CONSULTATION RESPONSE:

Application No. 2024/93458/E (Re-submitted Refused Application 2023/62/92191/E) – 62 Houses, Cliffe Hill, Denby Dale

SF3282 TPP01 Tree Protection Plan and Method Statement

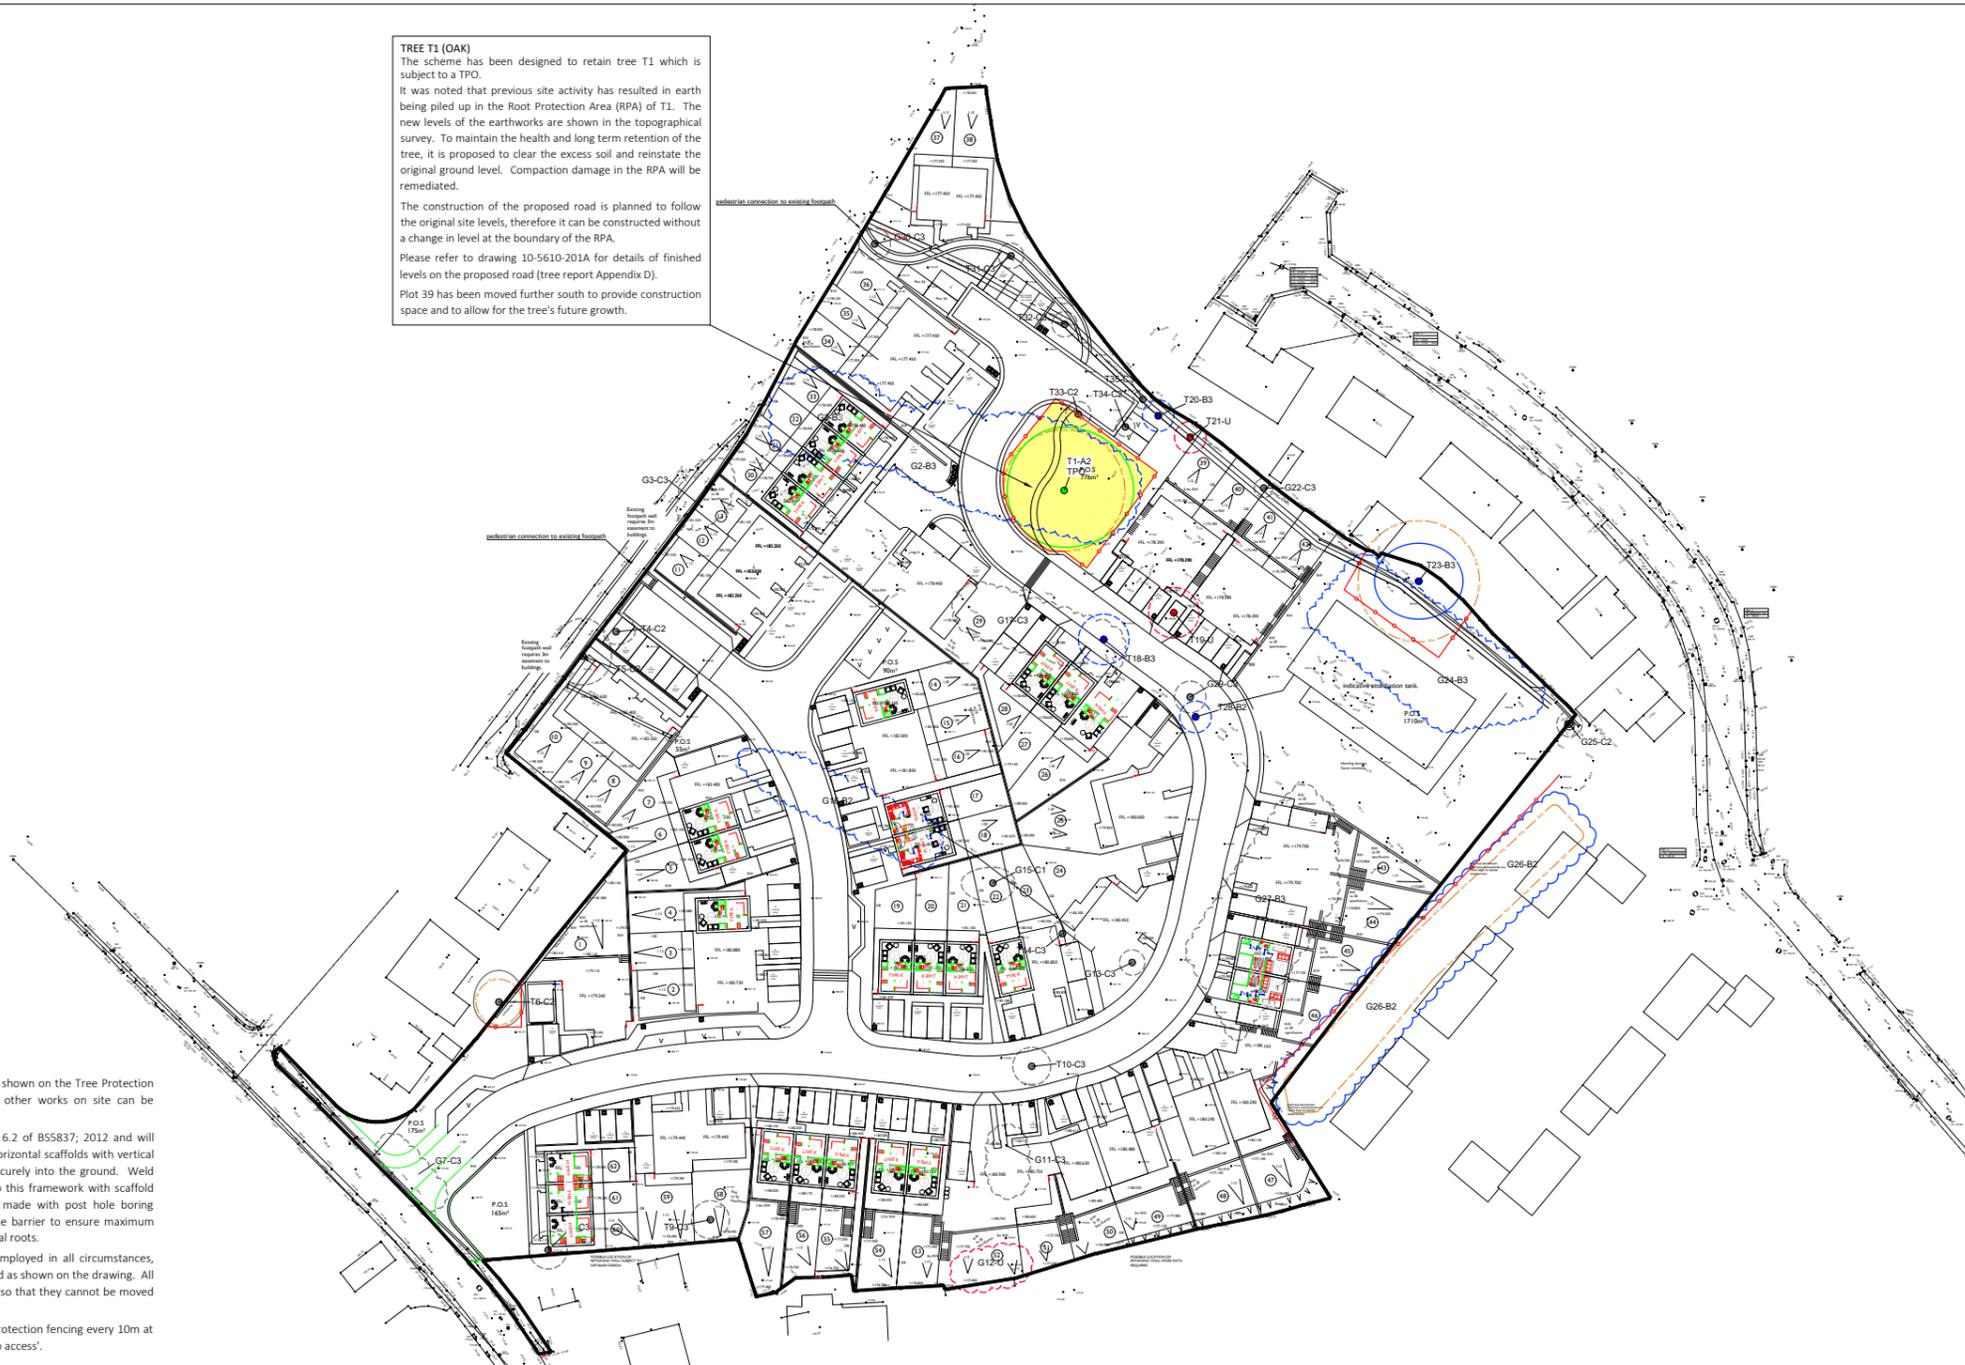
LP33 and LP24 – in respect of tree protection. Plot 39 is nearly under the canopy of the protected tree.

PROPOSED
SITE PLAN

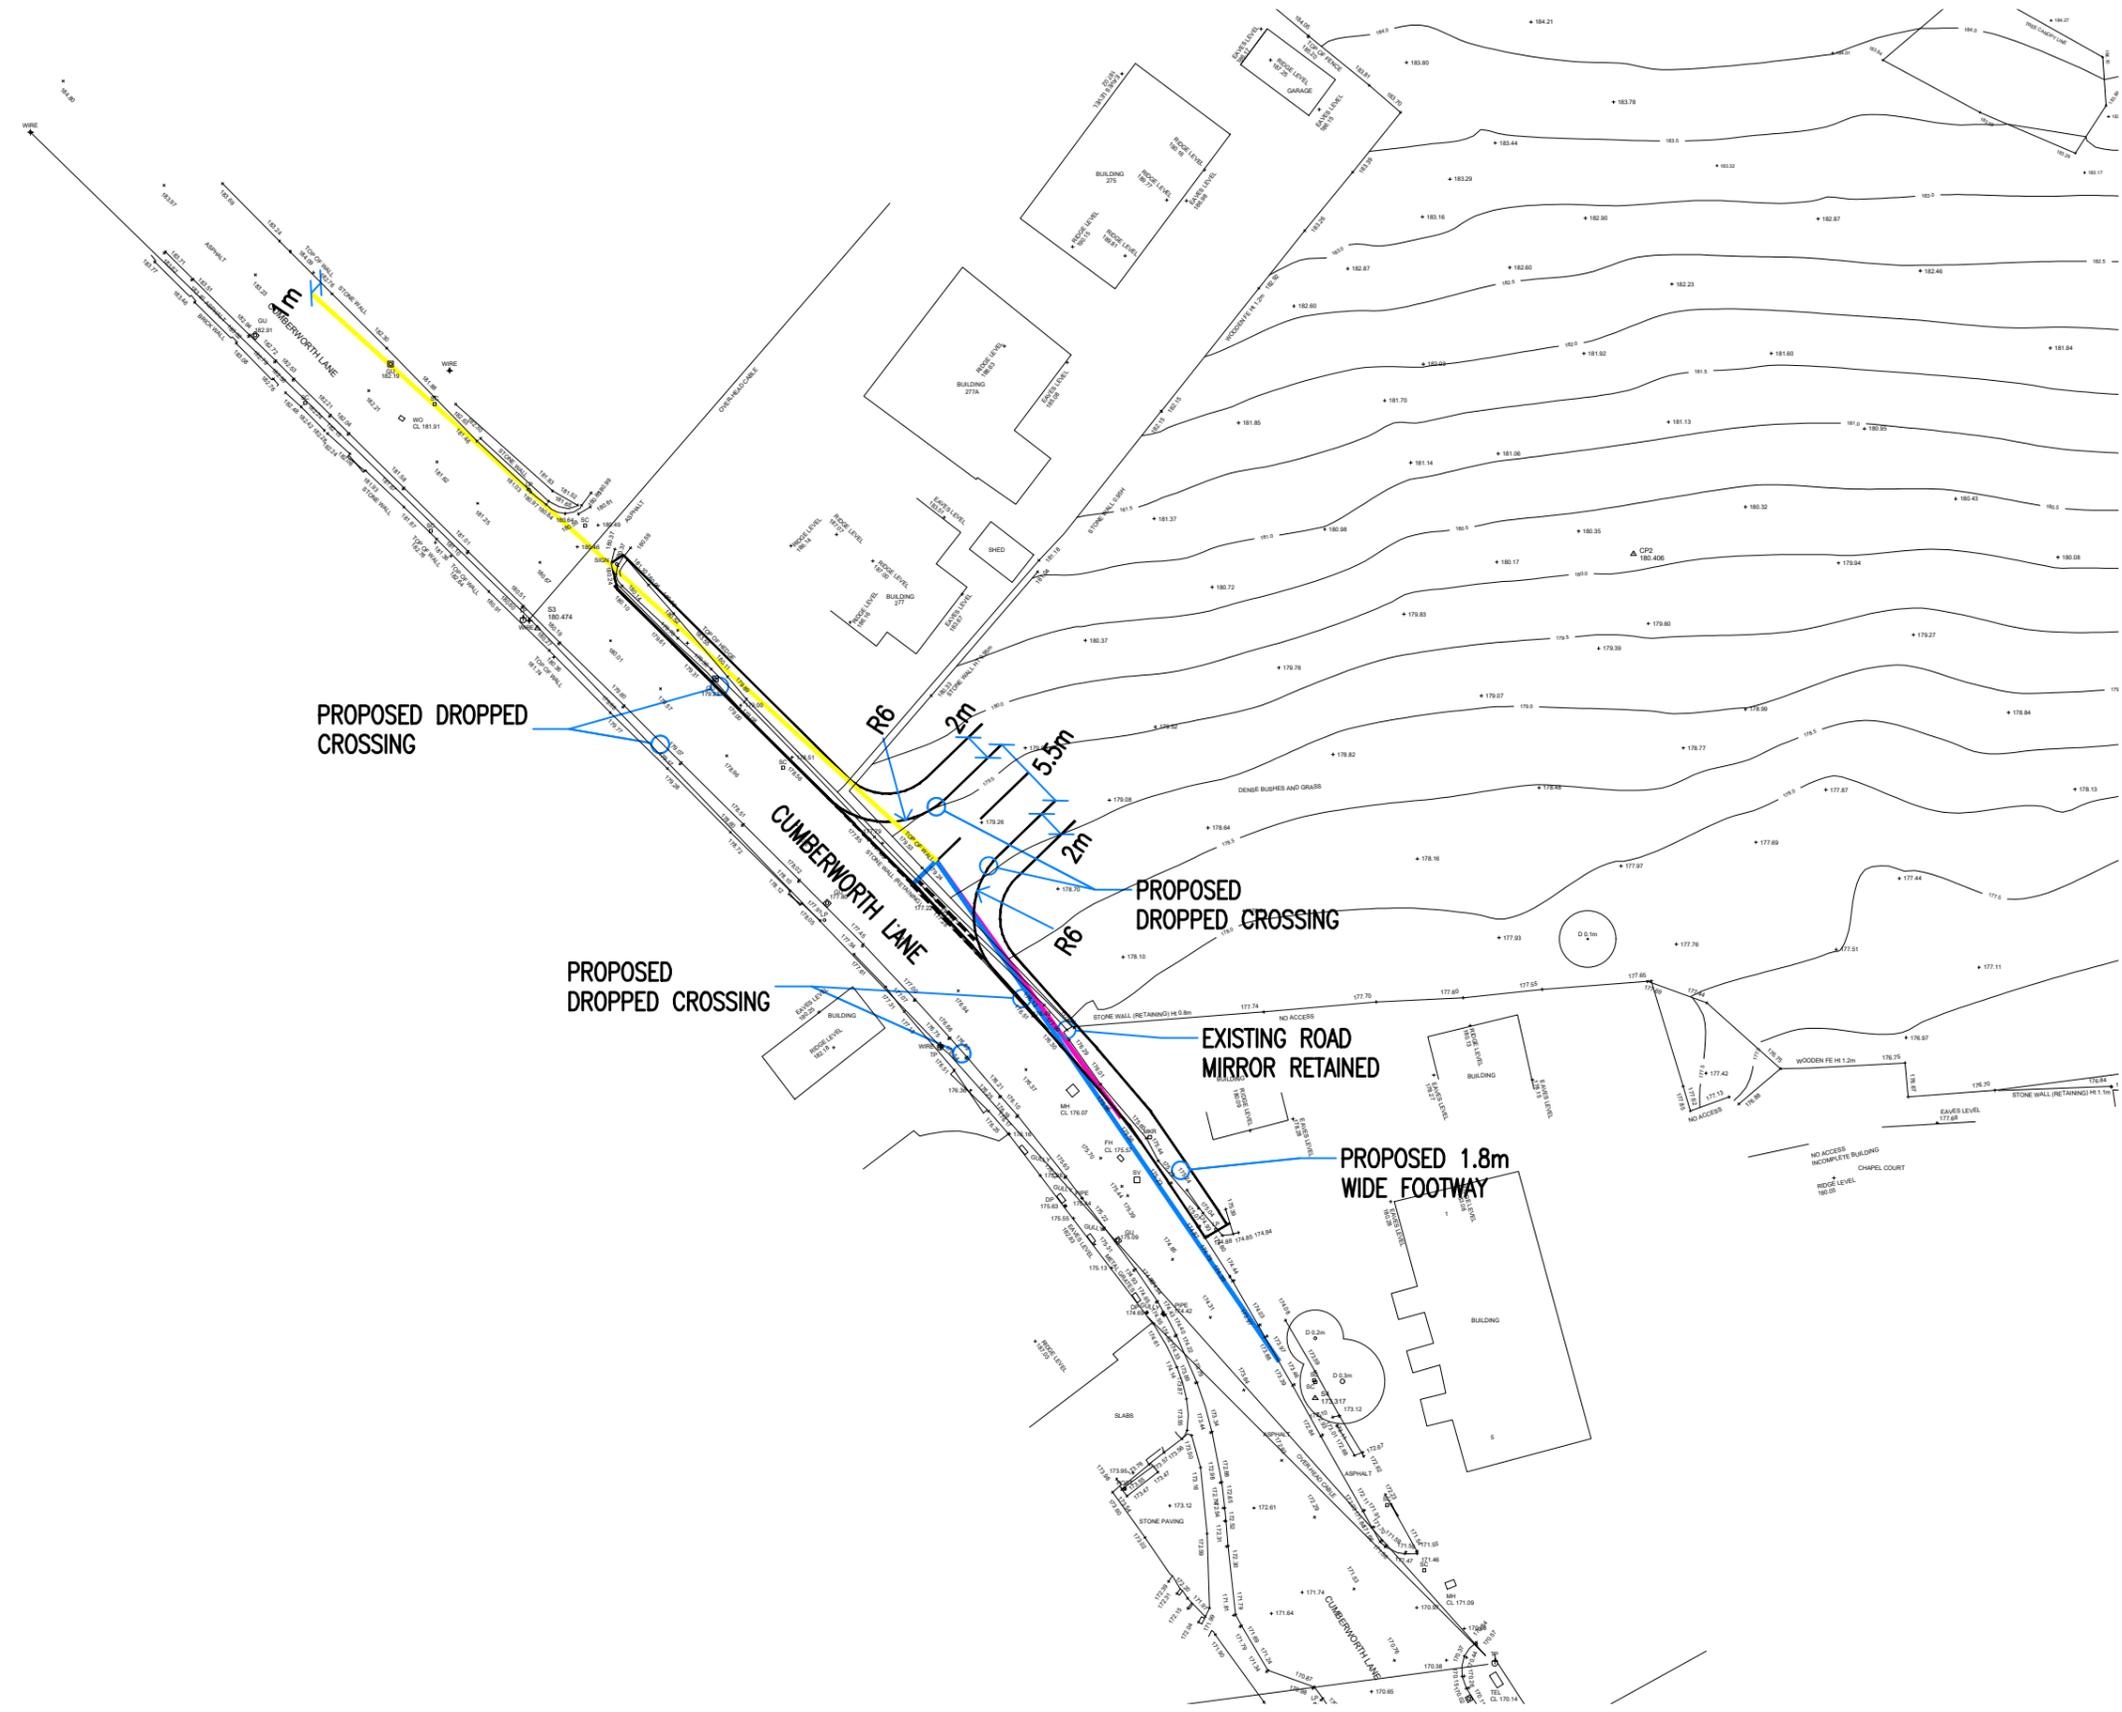
Neither has the Transport Assessment been updated with the latest site plan.

The Geological consultant has also been supplied with an out-of-date site plan which is particularly concerning given that there's a suggestion in reports that the level of remediation work underground could be differentiated depending on what is to be constructed above ground. It is suggested that garden areas need little or no support which is particularly worrying given the highly unstable nature of the hillside and the fact that many gardens will have retaining walls up to 3.5 m high (including the use of gabions). This ultimately will be privately owned land and residents potentially landed with huge dangers and liabilities.

- We believe the road layout will not be acceptable as the LPA prefer a circular road layout so service vehicles (ie. refuse collection vehicles) do not have to make excessive reverse/3point turn movements. The road is very narrow and just one parked car is likely to cause access problems for RCVs.

PROPOSED ACCESS ARRANGEMENT

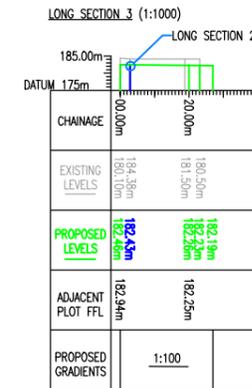
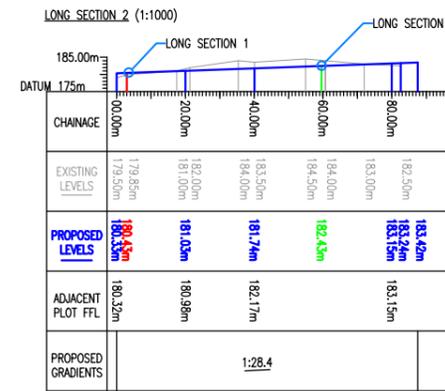
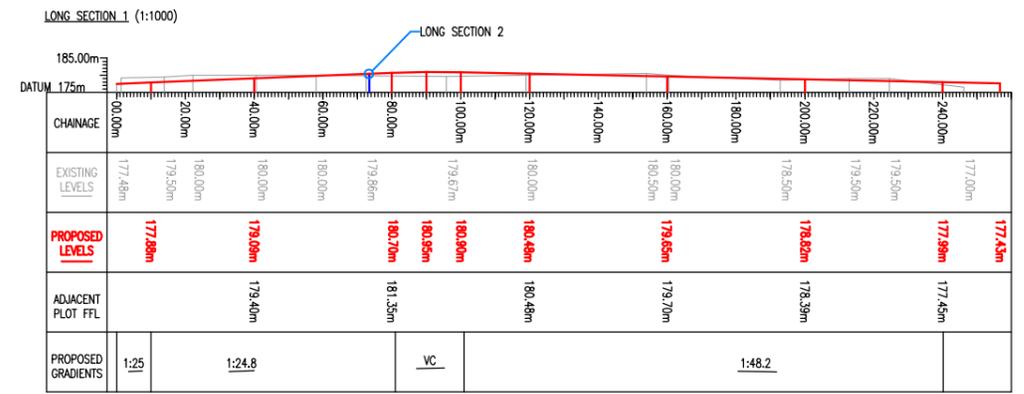
The proposed access is at a particularly constricted part of Cumberworth Lane with very limited visibility splays. As the largely unconvincing Transport Assessment shows, the **average speed** of traffic is nearly 5mph above the speed limit, requiring a stopping distance of around 29.16M – far greater than the left hand 22m visibility splay from the proposed site entrance. (*See further comments on the Transport Assessment below*).

A Tracking Plan has been provided to show that an RCV can negotiate left and right turns out of the site. Firstly, the plan omits to show the end of the Methodist Church which juts out into Cumberworth Lane. Secondly, the RCV would have to swing out into oncoming traffic on the opposite carriageway. Thirdly, the space is so tight it is likely the RCV superstructure would catch anyone on the very narrow pavement opposite the proposed entrance.

The applicant has not demonstrated how large construction traffic vehicles (likely with trailers) will be able to negotiate the proposed access on this narrow lane without endangering road users and pedestrians.
